Grading and Site Servicing Plan

New Campus Development for
The Ottawa Hospital
Phase 4: Main Hospital Project
Ottawa, Ontario

re: Grading and Site Servicing Plan Review
The Ottawa Hospital - Civic Campus Redevelopment Project
951 Prince of Wales Road - Ottawa

file: PG6982-MEMO.06

DRAWING TITLE
SITE SERVICING PLAN
1 OF 5

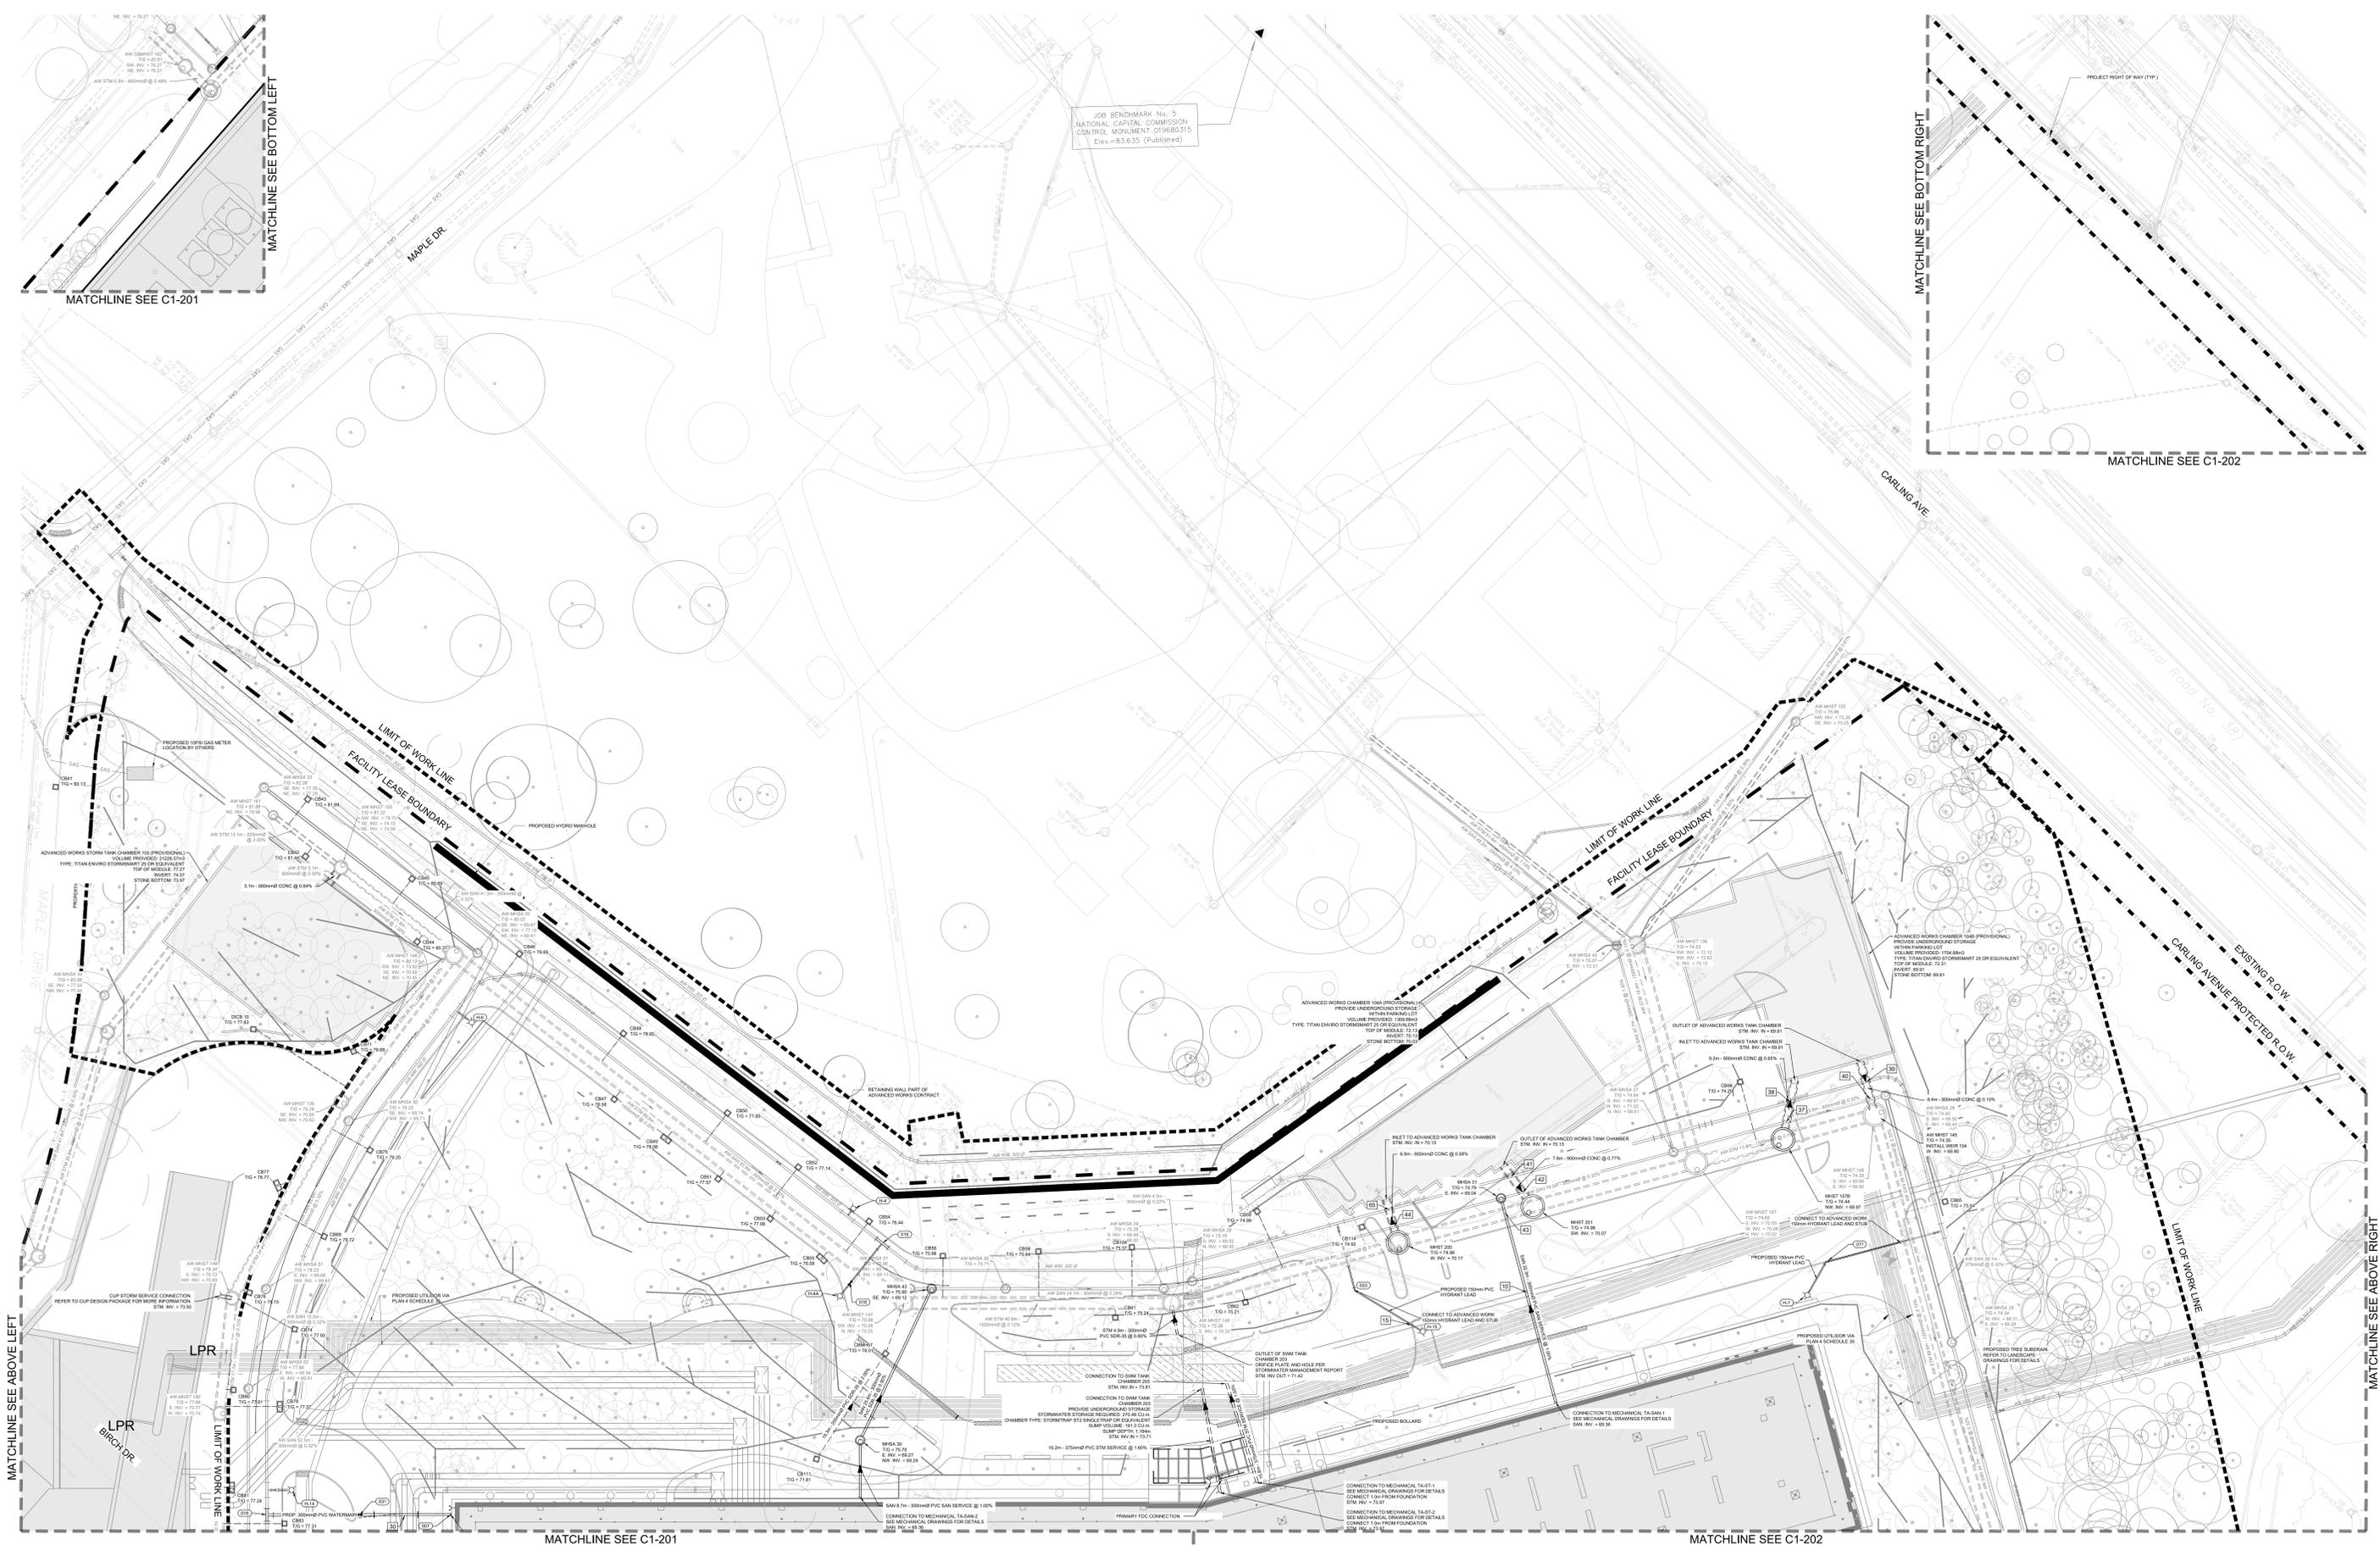
As per the City of Ottawa standards, all the storm and sanitary service pipes should be provided with a minimum of 2.0 m of soil cover for frost protection. Based on our review of the above-reference site servicing plans, some of the stormwater service pipes along the east side of the building - between MHST 213 to MHST 214 and between MHST 211 to the building, were observed to have less than 2.0 m of soil cover for frost protection.

Where insufficient soil cover (i.e.- less than 2.0 m) is available for the stormwater pipes, the following frost protection criteria outlined in Table 1 is applicable.

Soil Cover Provided D (mm)	Insulation Dimensions (mm)	
	Thickness (mm)	Length (mm)
800 to 1,100	100	Extend 1,200 mm horizontally beyond the edge face of the pipe
1,100 to 1,400	75	Extend 900 mm horizontally beyond the edge face of the pipe
1,400 to 1,700	50	Extend 600 mm horizontally beyond the edge face of the pipe
1,700 to 2,000	50	Extend 300 mm horizontally beyond the edge face of the pipe

The rigid insulation should be placed 150 mm above the pipe on top of a compacted Granular A backfill and should have a minimum of 150 mm of Granular A or Granular B Type II backfill above the rigid insulation. Rigid insulation placed underneath roadways should consist of minimum HI-40 or equivalent.

As per the City of Ottawa standards, all watermain pipes are recommended to be provided with minimum 2.4 m of soil cover.

DRAWING TITLE: RETAINING WALLS - SITE LAYOUT

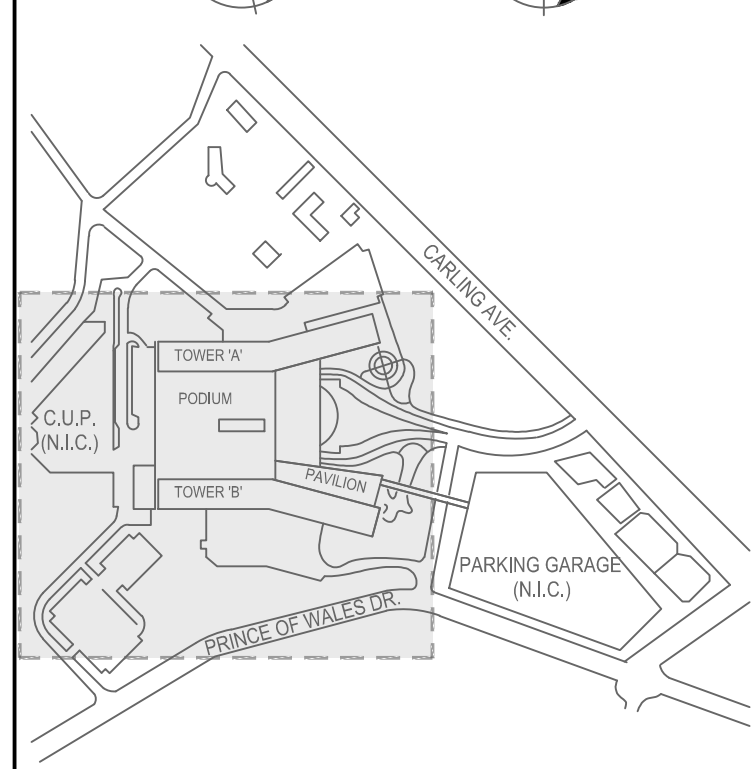
Based on our review, of the above-mentioned Grading and Site Servicing Plans, the section of the stormwater pipe between MHST 214 to the SWM Tank Chamber 201 and the SWM Tank Chamber 201 will be located within the lateral support zone of the **Retaining Wall #3**. Furthermore, the proposed watermain service pipe to be located along the southeast of **Retaining Wall #4** was also noted to be within the lateral support zone of the proposed retaining wall. It should be noted that these retaining wall designs should ensure future maintenance of the services within these sections.

Furthermore, some of the proposed retaining walls along the north side of the building are to be located in close proximity to the proposed and existing underground services. Given the depth of these services, the retaining walls are not expected to impose any significant additional loading. However, any future excavation required for repair or maintenance of these services following construction of the retaining walls should be appropriately shored to maintain the integrity of the retaining walls and protect their lateral support zones.

DRAWING TITLE: SITE GRADING PLAN 4 OF 5

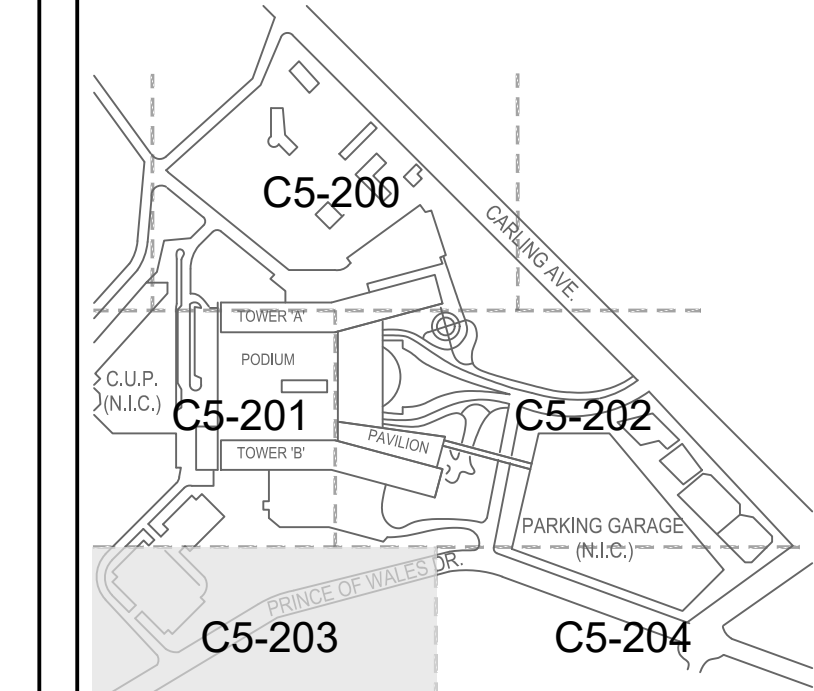
Based on our review of the above-mentioned site grading plans, the majority of the proposed grades were noted to be at or below the existing ground surface elevation. Paterson reviewed all the slopes, grading and retaining walls across the site. Based on our review, the grading across the site is considered acceptable.

Therefore, based on our review of the above noted drawing in consideration of the subsurface profile encountered at the time of our investigation, the grading is considered acceptable from a geotechnical perspective. No additional measures such as lightweight fill or settlement monitoring programs will be required to accommodate the proposed finished grades as noted on the aforementioned grading plan.
